M5 Junction 10 Improvements Scheme

**Applicant Response to Examining
Authority's Third Written Questions**

TR010063 - APP 9.93

M5 Junction 10 Improvements Scheme Development Consent Order 202[x]

Drawing Title
**STRUCTURAL DETAILS
NEW WEST CHELTENHAM LINK ROAD
RIVER CHELT BRIDGE
SHEET 4 OF 12**

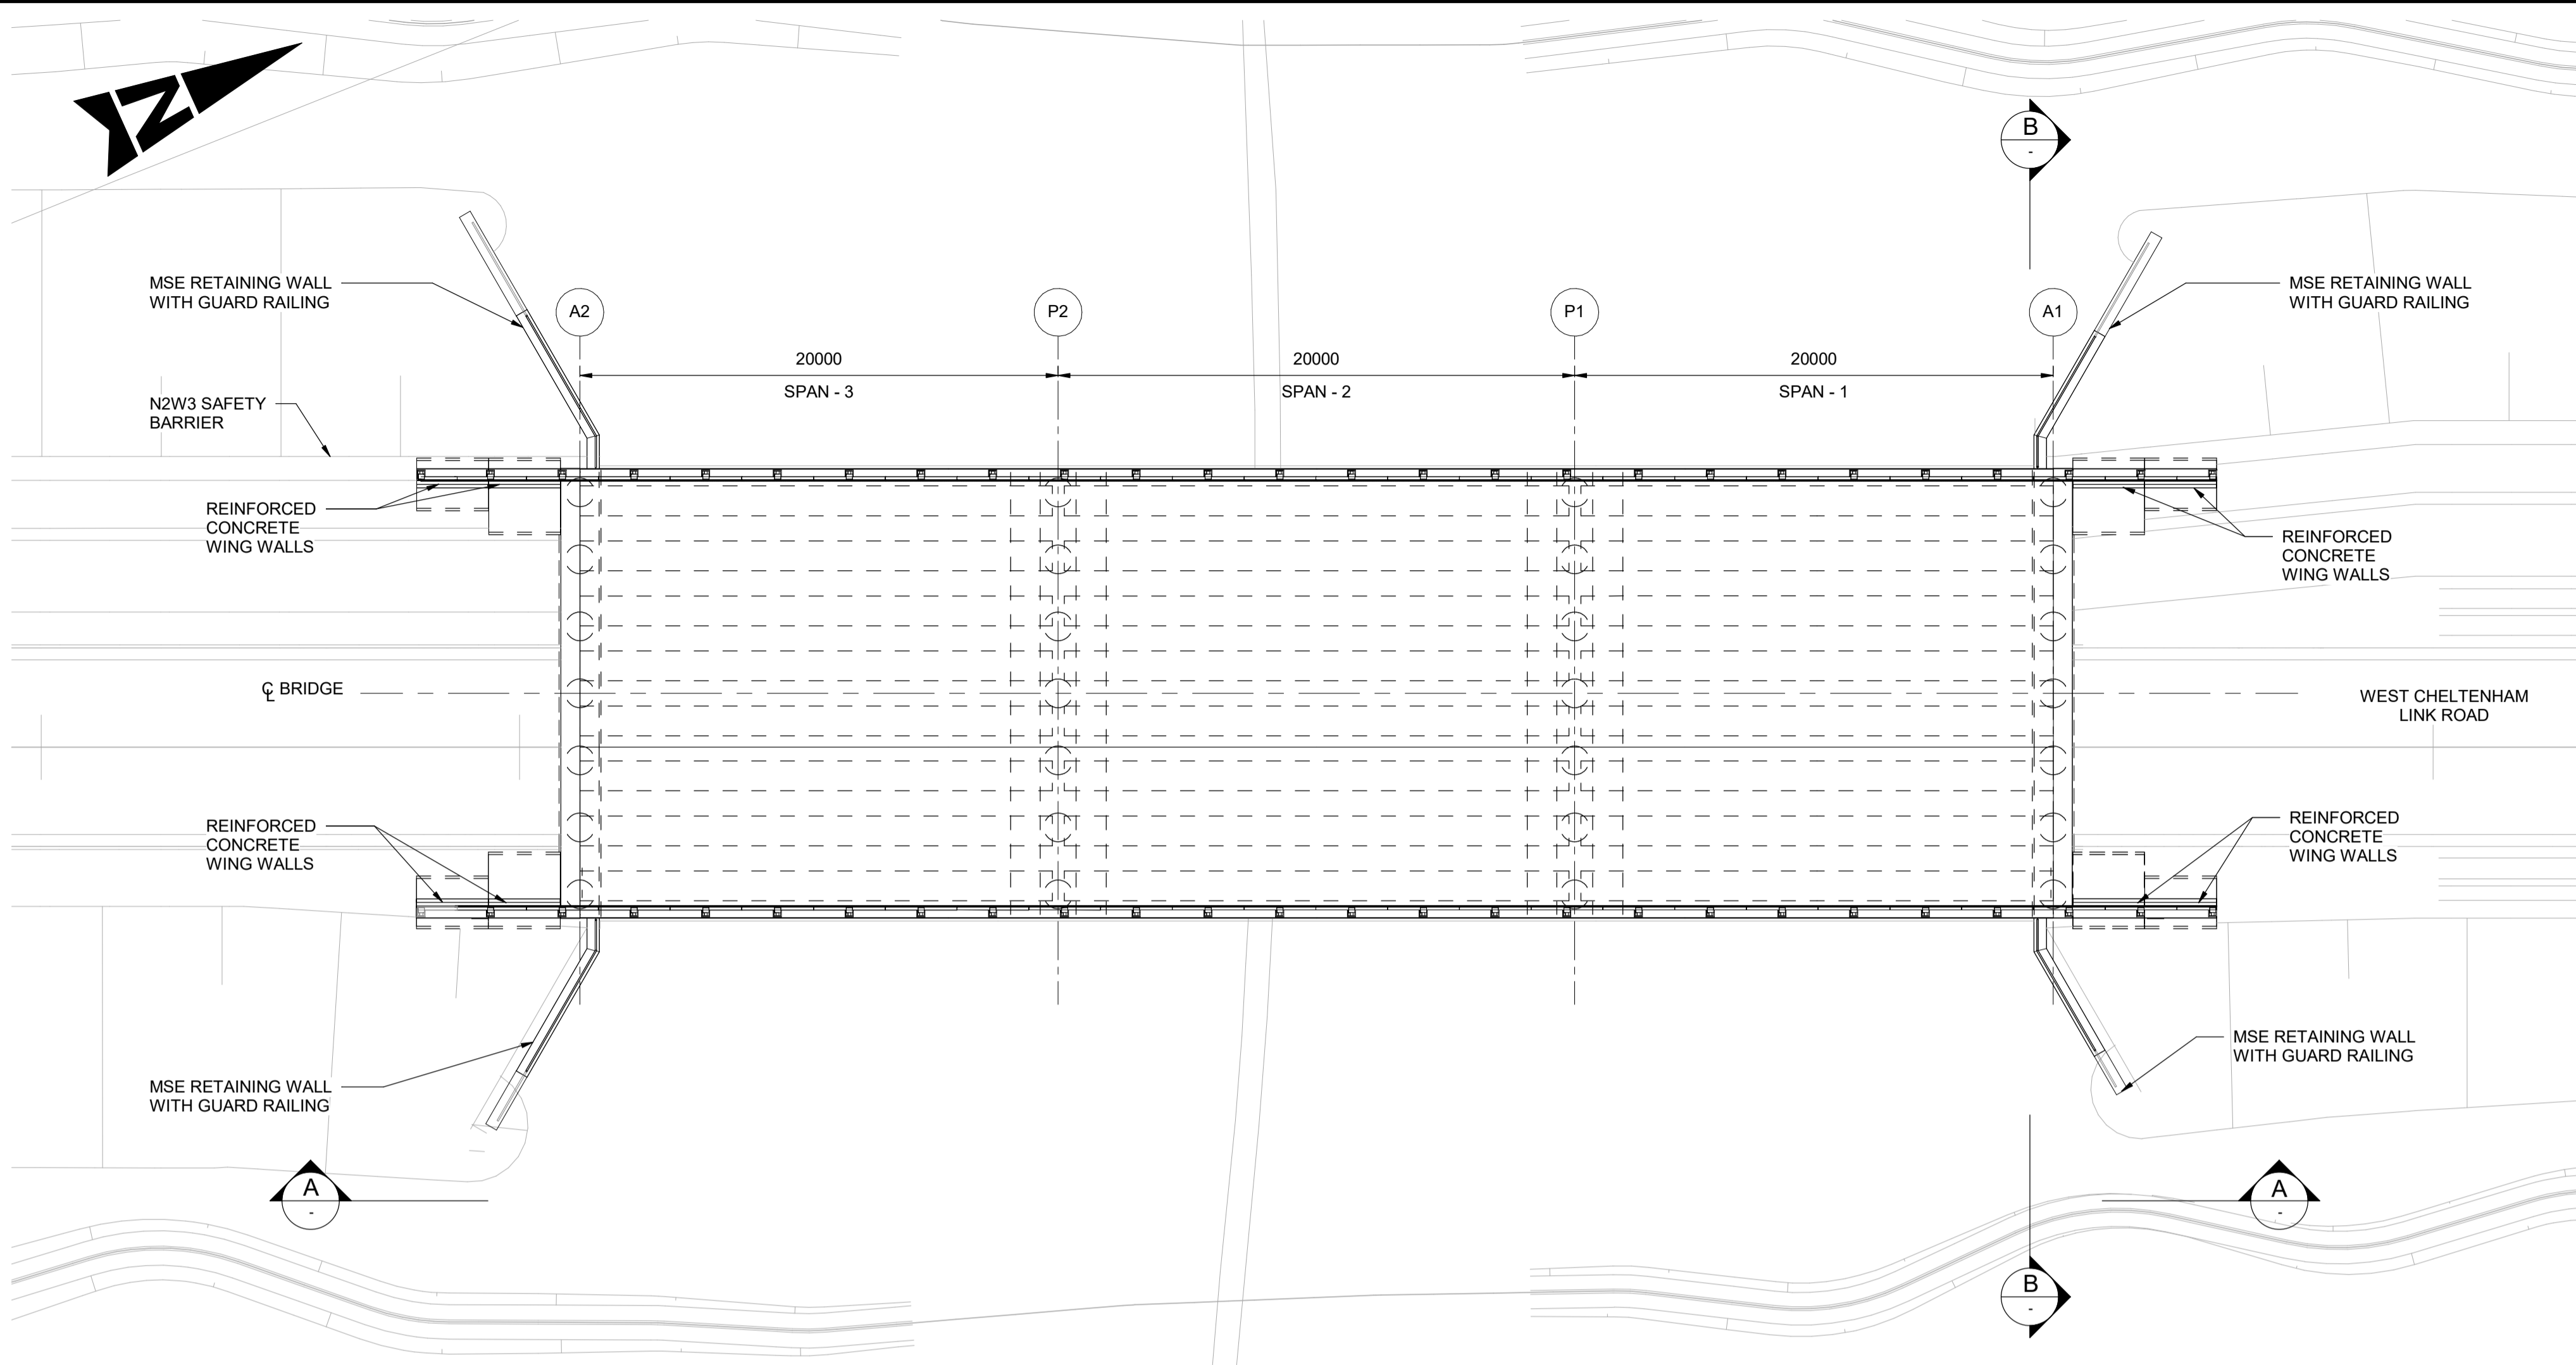
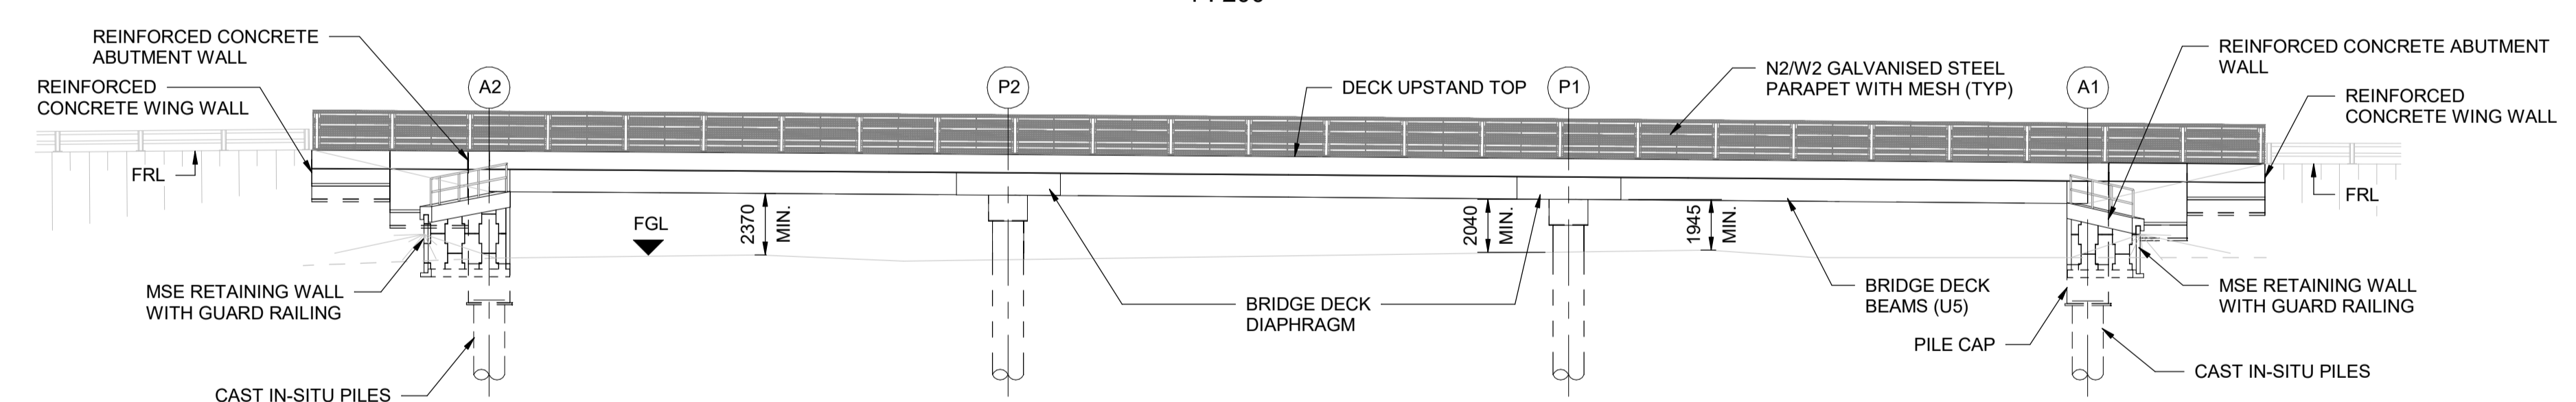
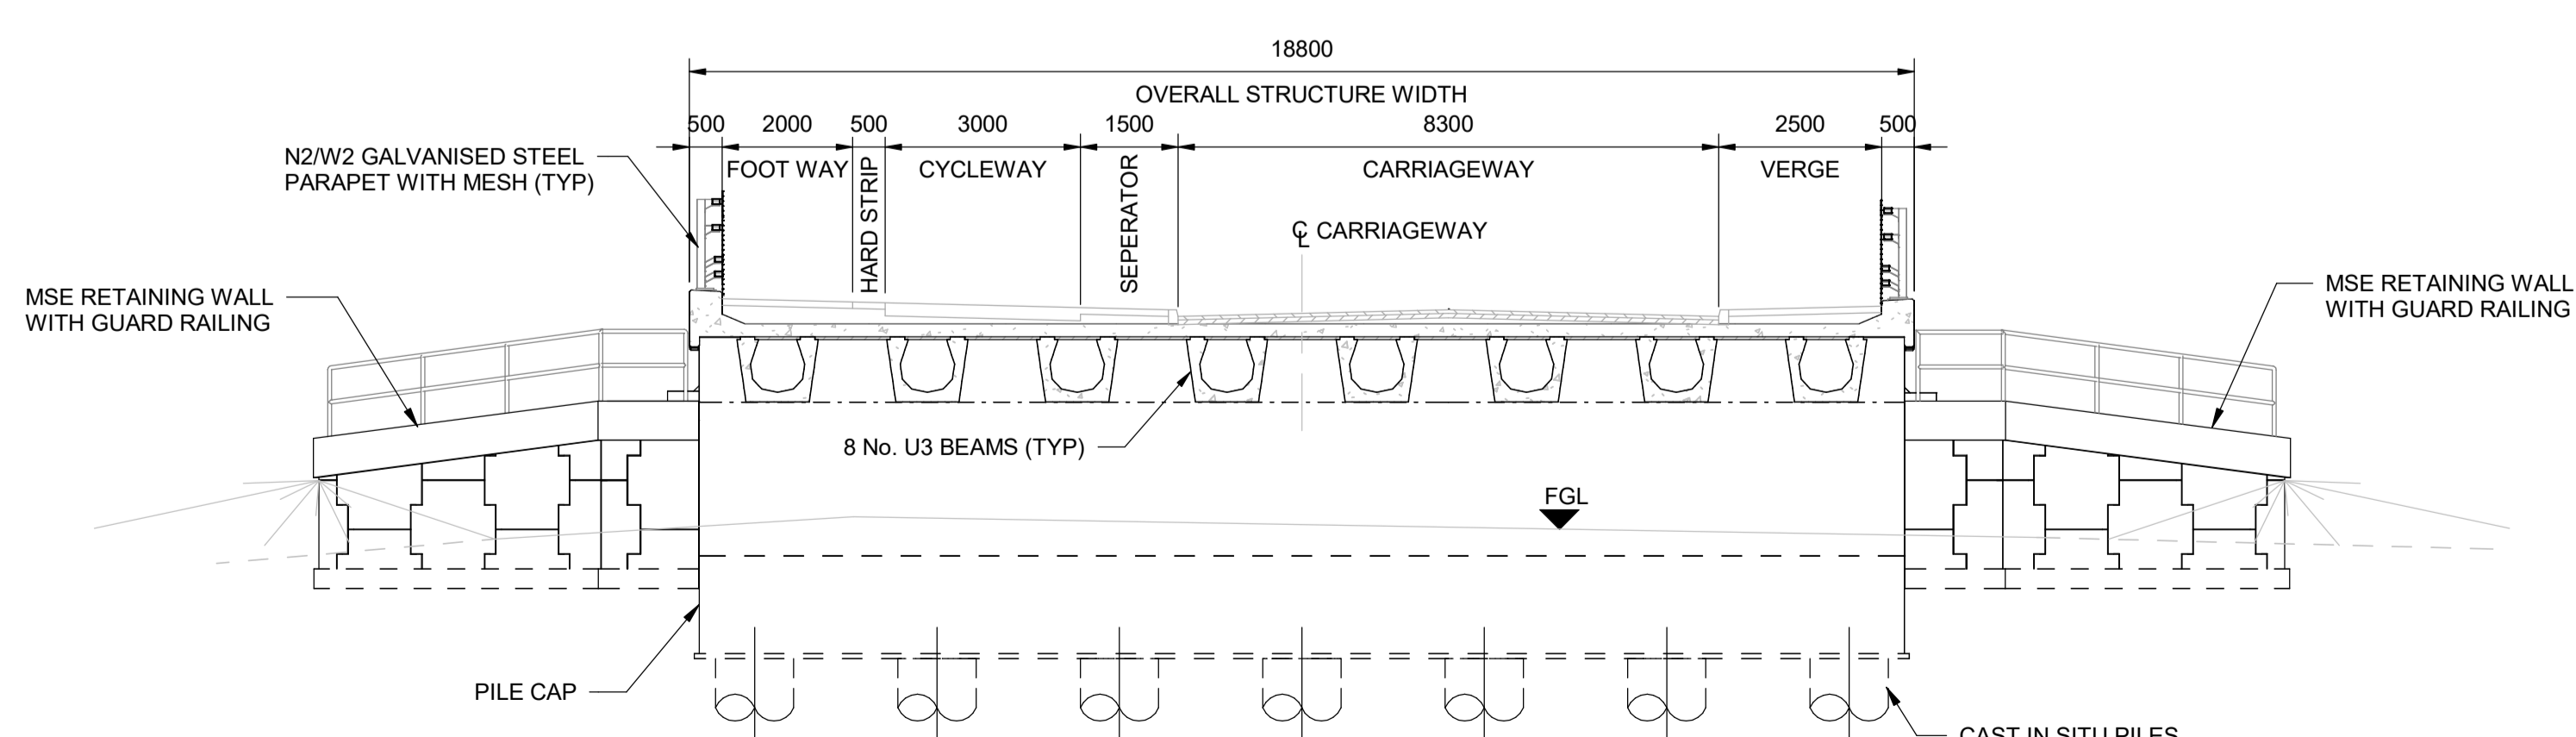
Q1.0.2	The Applicant	<p>Plans</p> <p>Sheet 4 of 12 the Cross-section BB [AS-103] would appear not to be correctly labelled please update or explain the drawing/plan.</p>	<p>An updated drawing package will be submitted at Deadline 10.</p>
Q1.0.3	The Applicant and National Highways	<p>Consistency of Information</p> <p>In both the original RR from NH [RR-026] Item 1.4 (c), (d), the SoCG [REP3-037] Items 4.1 and 4.3 and the subsequent PADSS [REP5-038] issues</p>	<p>The Applicant can confirm that SoCG (REP3-037) Items 4.1 and 4.3 have been resolved with National Highways as a result of updates to the land plans, Book of Reference and Statement of Reasons and confirmed in their updated PADSS (PADSS items 9</p>
